Bioenergy with Carbon Capture and Storage (BECCS) at Drax Power Station

Proposed Changes Consultation Booklet
21 October – 20 November 2022

We are holding this consultation specifically to get your views on two proposed changes to the submitted Application for the Scheme, which are as follows:

Plate 1-1 - Drawing Showing Location of OHL1 and TCL1

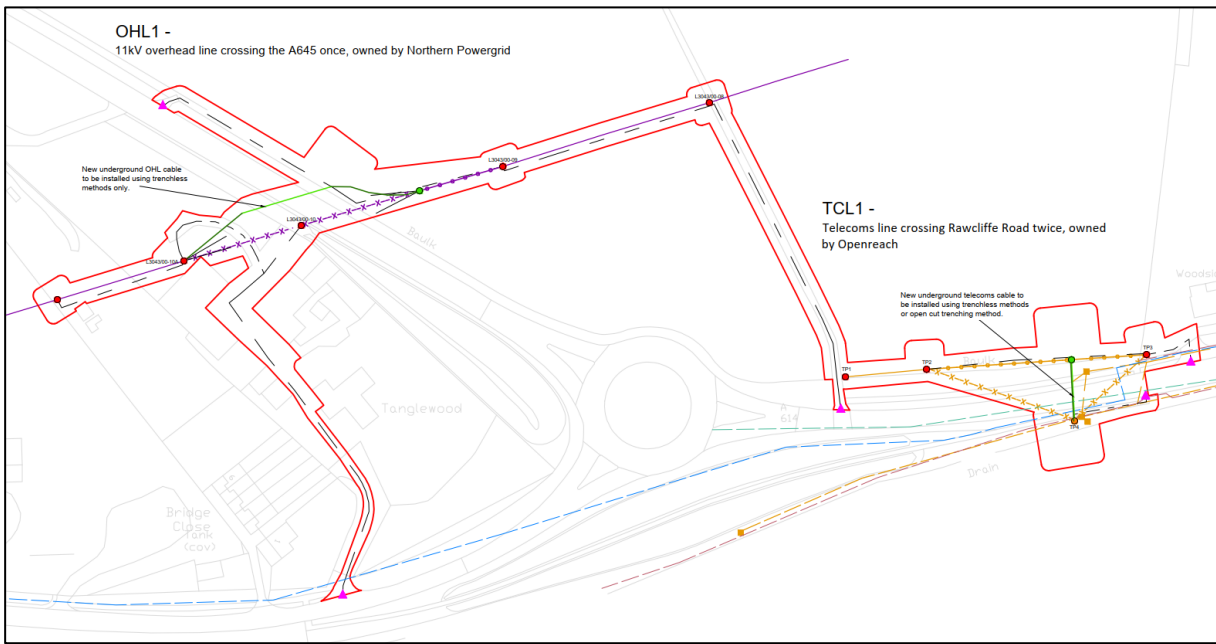
- Location '1' on sheet 4 of the ARoW Plans is in the incorrect location and the plan will need to be amended as part of the Proposed Change;
- Undergrounding is the preferred approach although the final design for the relocated assets may include an element of a slight realignment of the existing OHLs and restringing works;
- Undergrounding needs to take place for the section of the electrical OHLs which is supported by telegraph poles i.e. from 'pole to pole' rather than just for the section of OHL which sits over the highway. The poles which relate to the OHLs shown on the ARoW Plans are located outside of the highway boundary;

In addition, Drax is in discussions with the owner of the two telecommunications OHLs (Openreach Limited) which pass over Rawcliffe Road (A614) and is seeking to confirm the requirements for the works to these telecommunications assets to facilitate access for the AILs during the construction stage of the Scheme. Drax notes that if the same position applies to these assets as for the electrical OHLs, then 'additional land' will be required to accommodate works to telecommunications assets, for the same reasons as identified above for the electrical OHLs, to underground the telecommunications OHLs, as the relevant telegraph poles are also located outside of the highway boundary.

PROJECT No: 70072063	DRAWING No: 70072063-FCA-1	REV: A
--------------------------------	-------------------------------	------------------

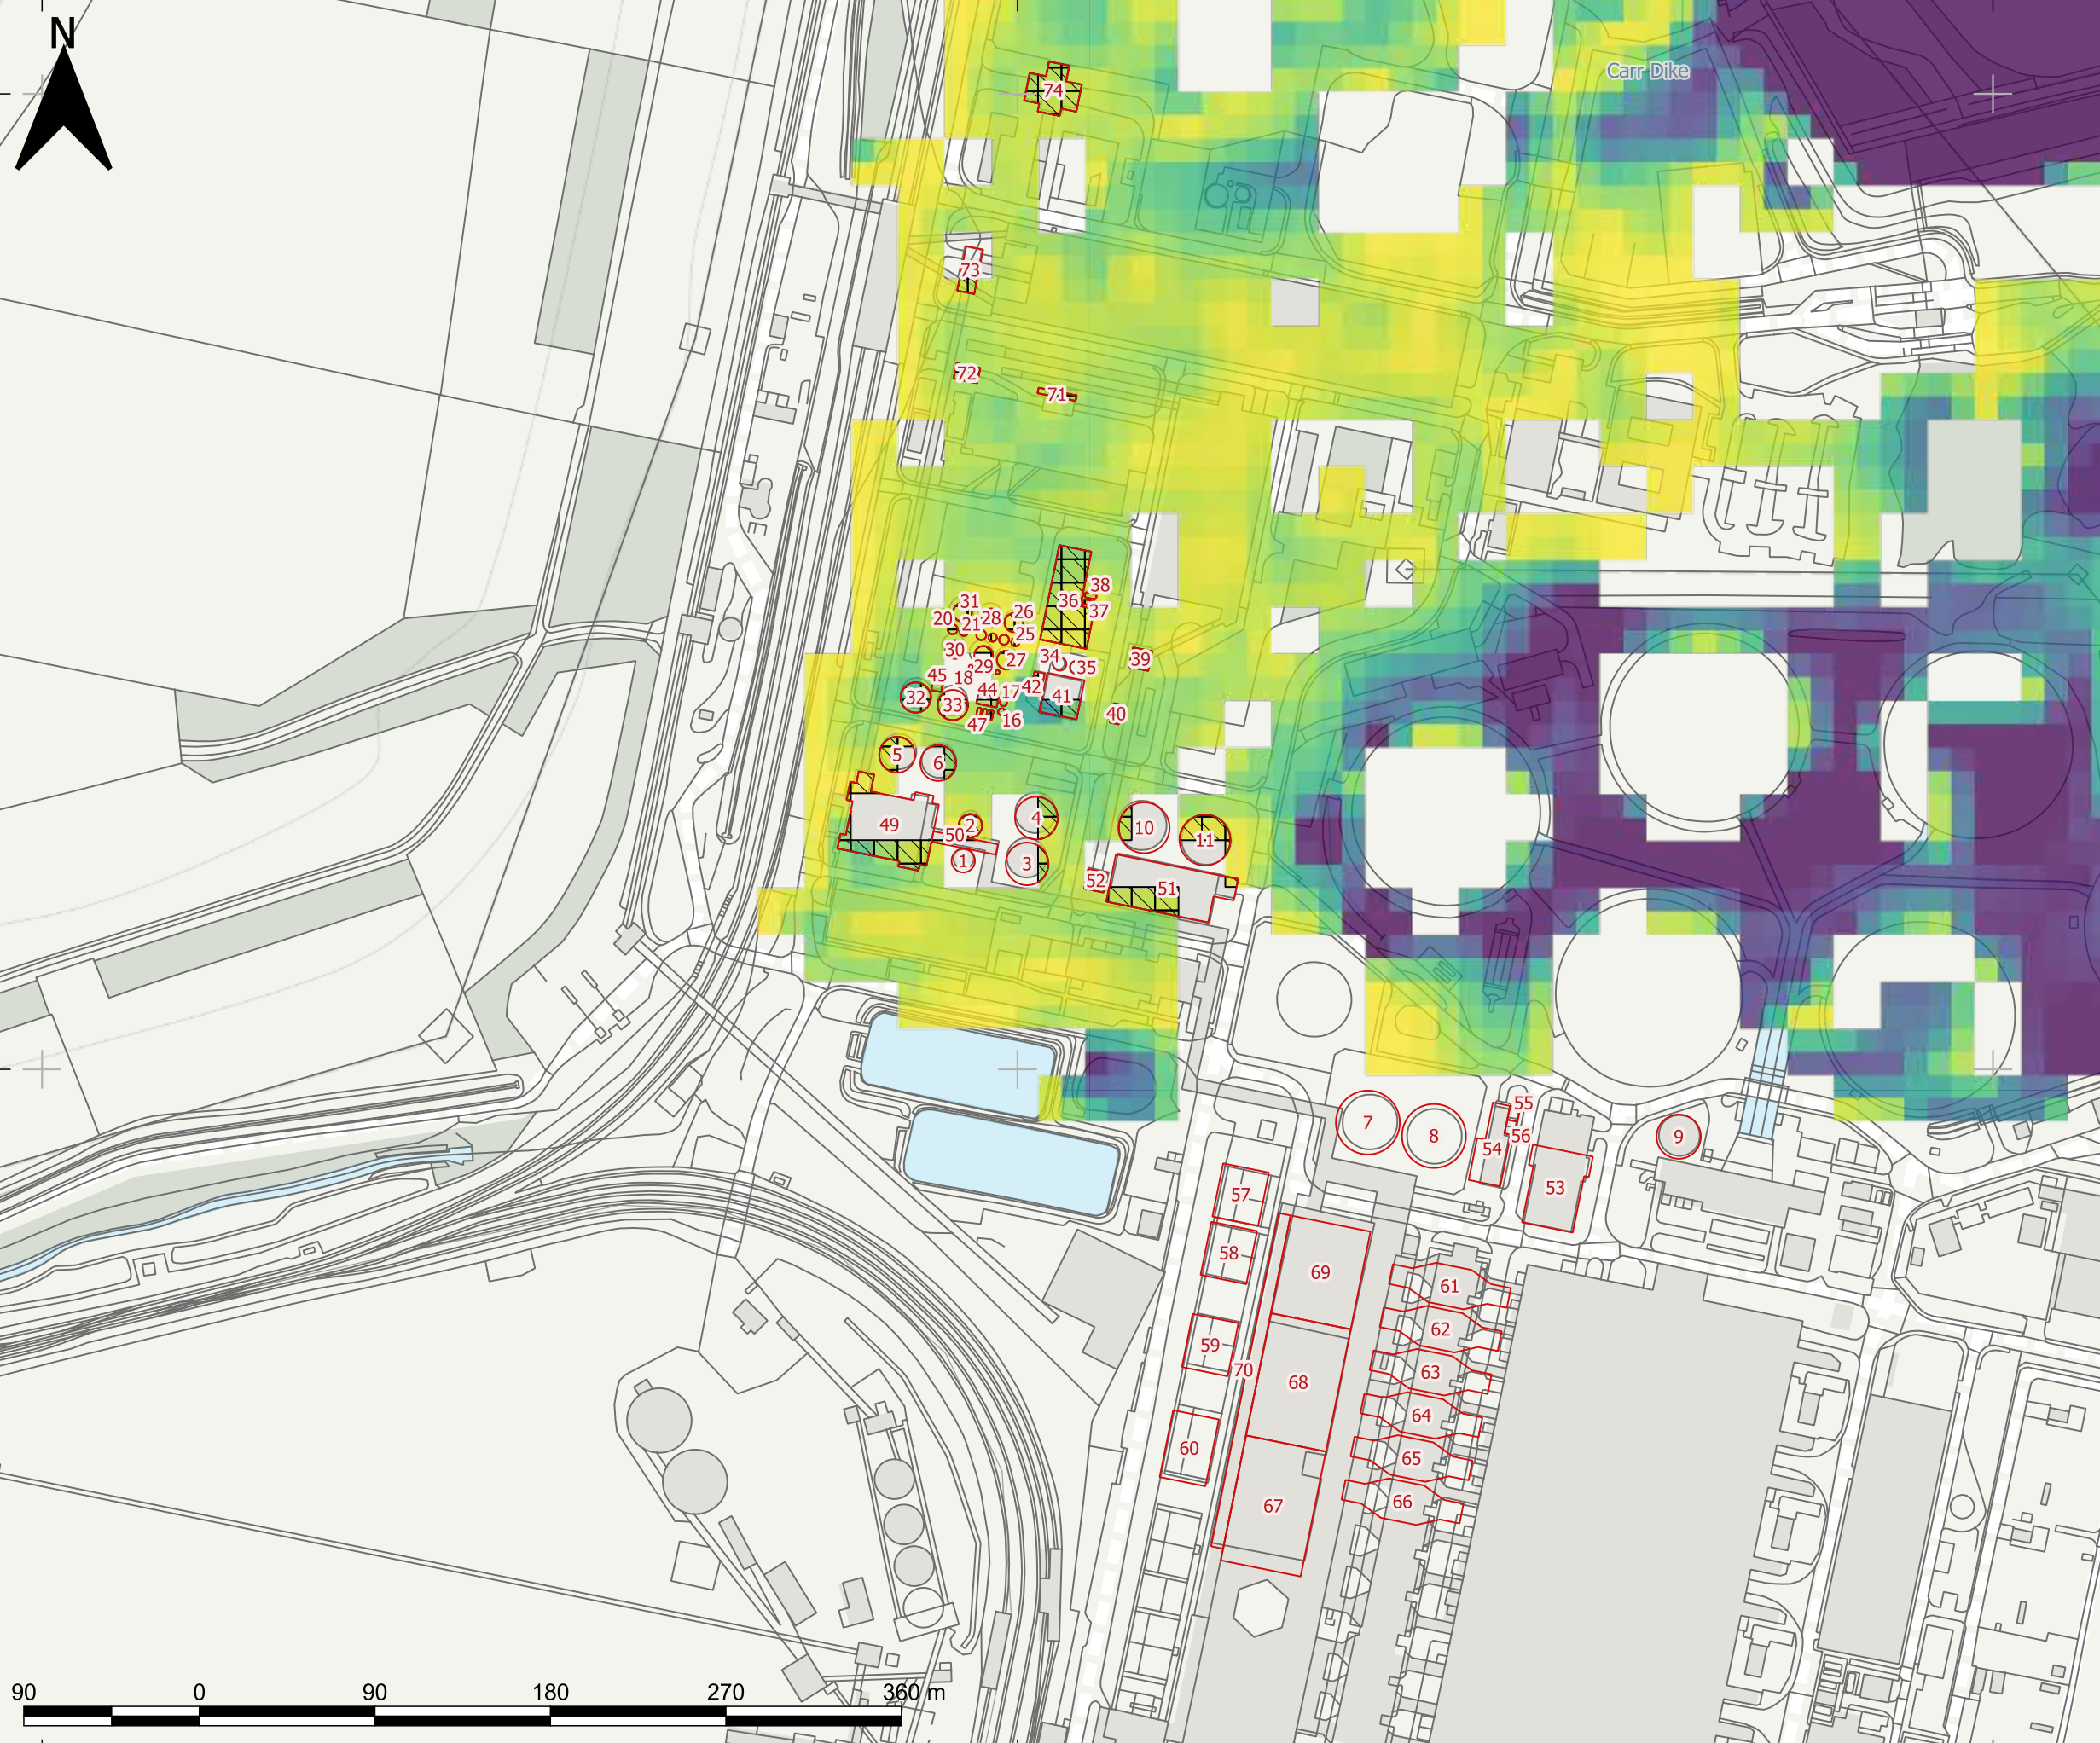
Proposed Change PC-01 is required to mitigate against the slight loss of floodplain which arises as a result of the Scheme. Within the submitted Application* Drax committed to providing additional floodplain capacity (a minimum floodplain area of 1,889 m² will be created) through the lowering of ground currently outside the floodplain on land controlled by Drax. This land is referred to as the Floodplain Compensation Area (FCA).

The location of the proposed FCA works has now been finalised and is shown on the plan below. The land is owned by Drax and is currently use for grazing purposes by an agricultural tenant. The site of the

proposed FCA works comprises a field on the north of the Drax Power Station Site and would be subject to engineering operations to lower the north section of the existing ground levels to provide land which will be allowed to flood where necessary to provide additional floodplain capacity. It is anticipated that the material to be excavated to provide the FCA will be relocated to the southern section of the field, and the site landscaped to provide appropriate gradients of slope.

### Proposed Changes to Land Plans for OHL1

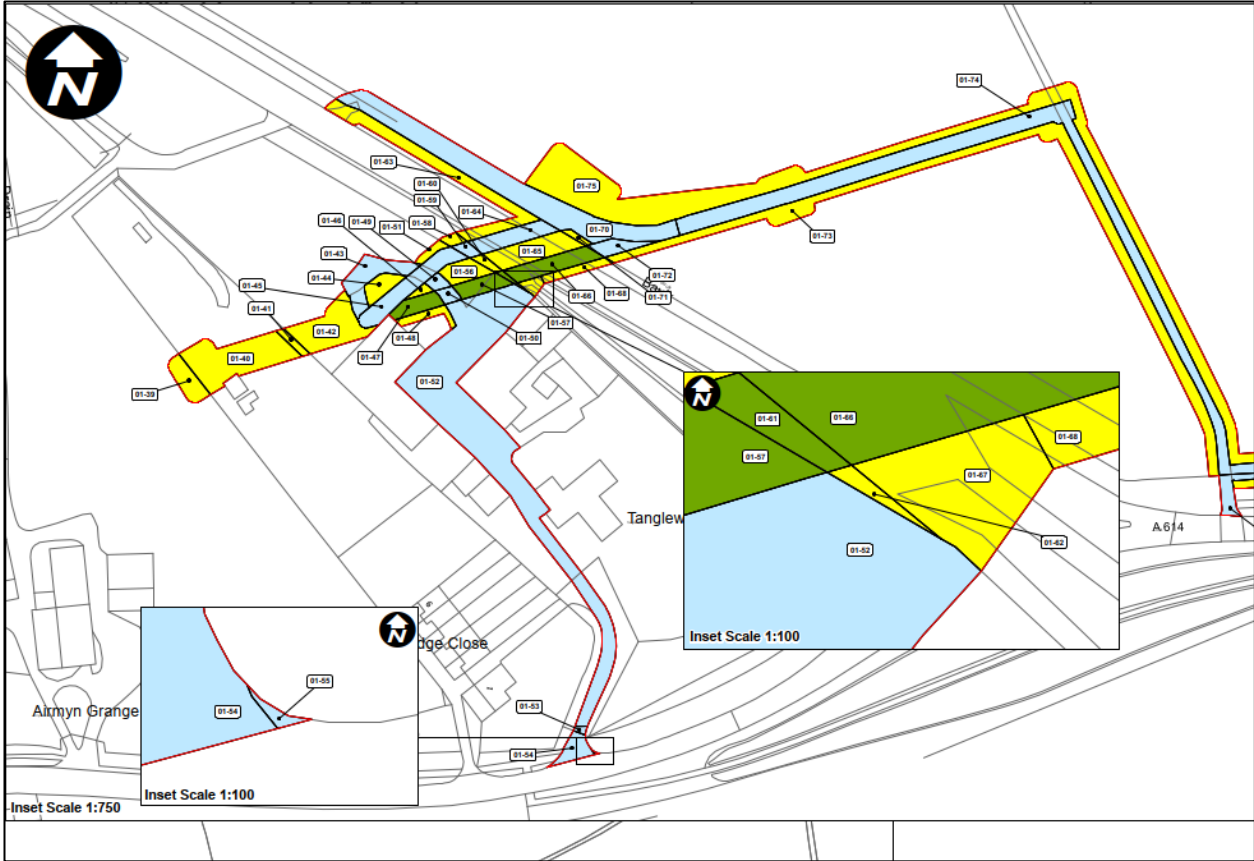
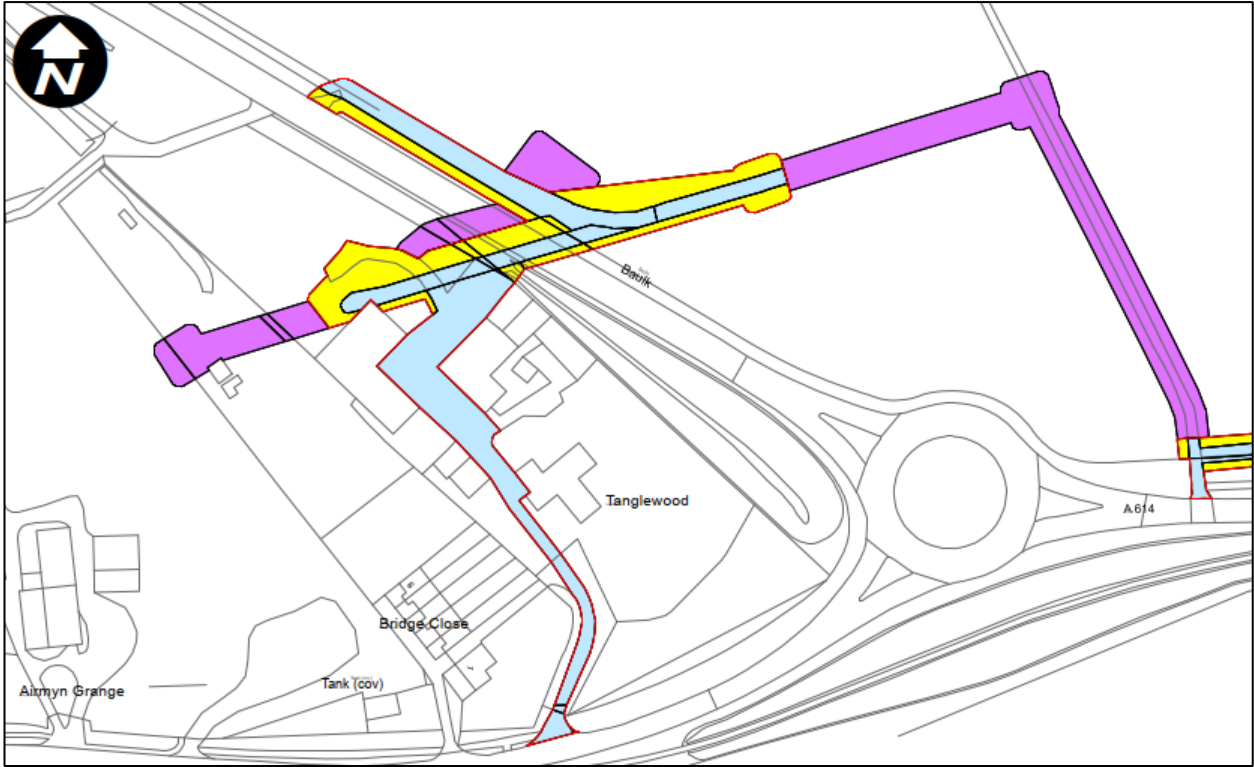
Proposed Change PC-02 is required to facilitate the delivery of Abnormal Invisibile Loads (AILs) to the Site during the construction phase of the Proposed Scheme. The draft DCO submitted with the Application (document reference APP-013) seeks powers to replace or underground overhead power and telecommunications lines at certain locations which are identified on the Access and Rights of Way Plans (document reference APP-011) (ARoW Plans). These powers are sought because the loads carried as part of the multiple AIL movements would be taller than or interfere with the operation of two electrical and two telecommunications OHLs, causing a conflict.

- Undergrounding of the electricity cables could be undertaken via horizontal directional drilling (HDD) or open trenching methods, as appropriate; and
- Third party land outside of Drax's ownership (known as 'additional land') would be required to access the poles and undertake the works. Furthermore, as the position of the electrical cables, be they undergrounded or realigned OHLs, may be different to the route of the existing OHLs, the DCO documentation will need to be updated to provide powers to enable the installation of the altered alignment of the electrical cabling (be they via undergrounded sections or OHLs), and to access and maintain the altered sections of electrical cabling in the future.

Proposed Change PC-02 will require a change to Application documentation. Third party land would be added to the Order Limits to provide the works powers to undertake the necessary works, as well as the powers of compulsory acquisition of rights over that third party land.
